**KIRKLEES METROPOLITAN COUNCIL
INVESTMENT & REGENERATION SERVICE**

Reference No: **2024/NM/93211/E**

Site Address: The Meadows, 3, Ash Farm Court, Thurstonland,
Huddersfield, HD4 6WR

Description: Non material amendment to previous permission
2024/91464 for erection of sun room, installation of
replacement windows and doors and alterations
(within a Conservation Area)

**north east elevation proposed**  
1 : 100

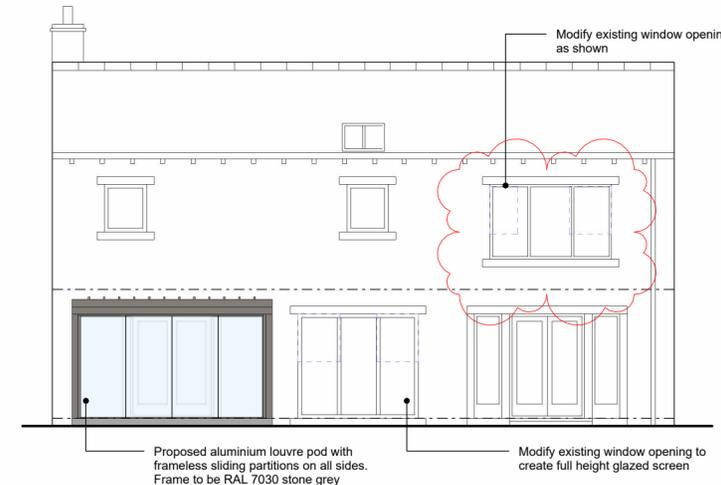
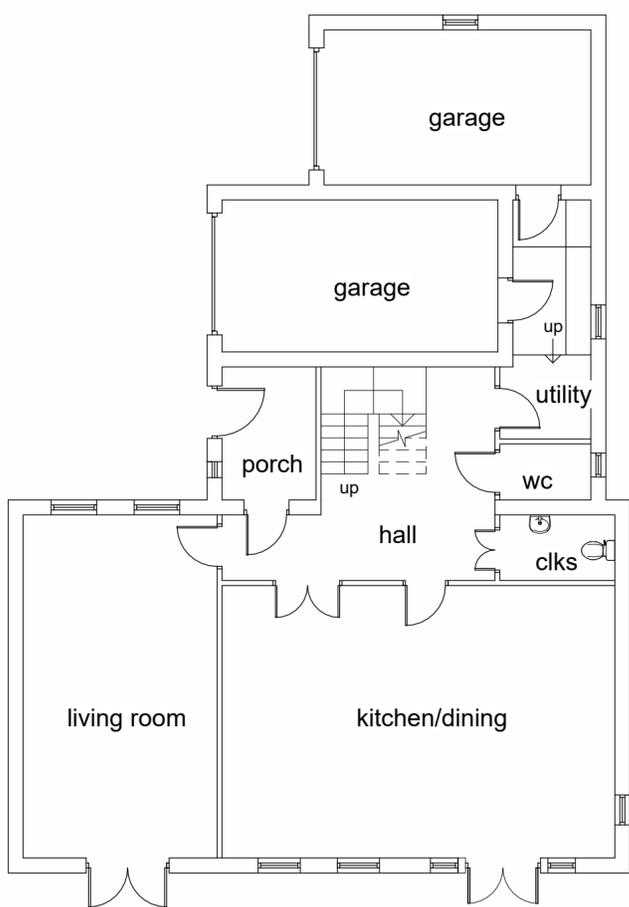
Overview: The applicant seeks a non-material amendment to amend the details of the windows on an existing dwelling. The alteration is for revisions to the first floor windows on the eastern side of the property to increase the scale of the windows to 1.5m

To conclude, the amendment shown on the submitted drawing 23072D-01-P011 to amend the window details in the rear elevation of the property is
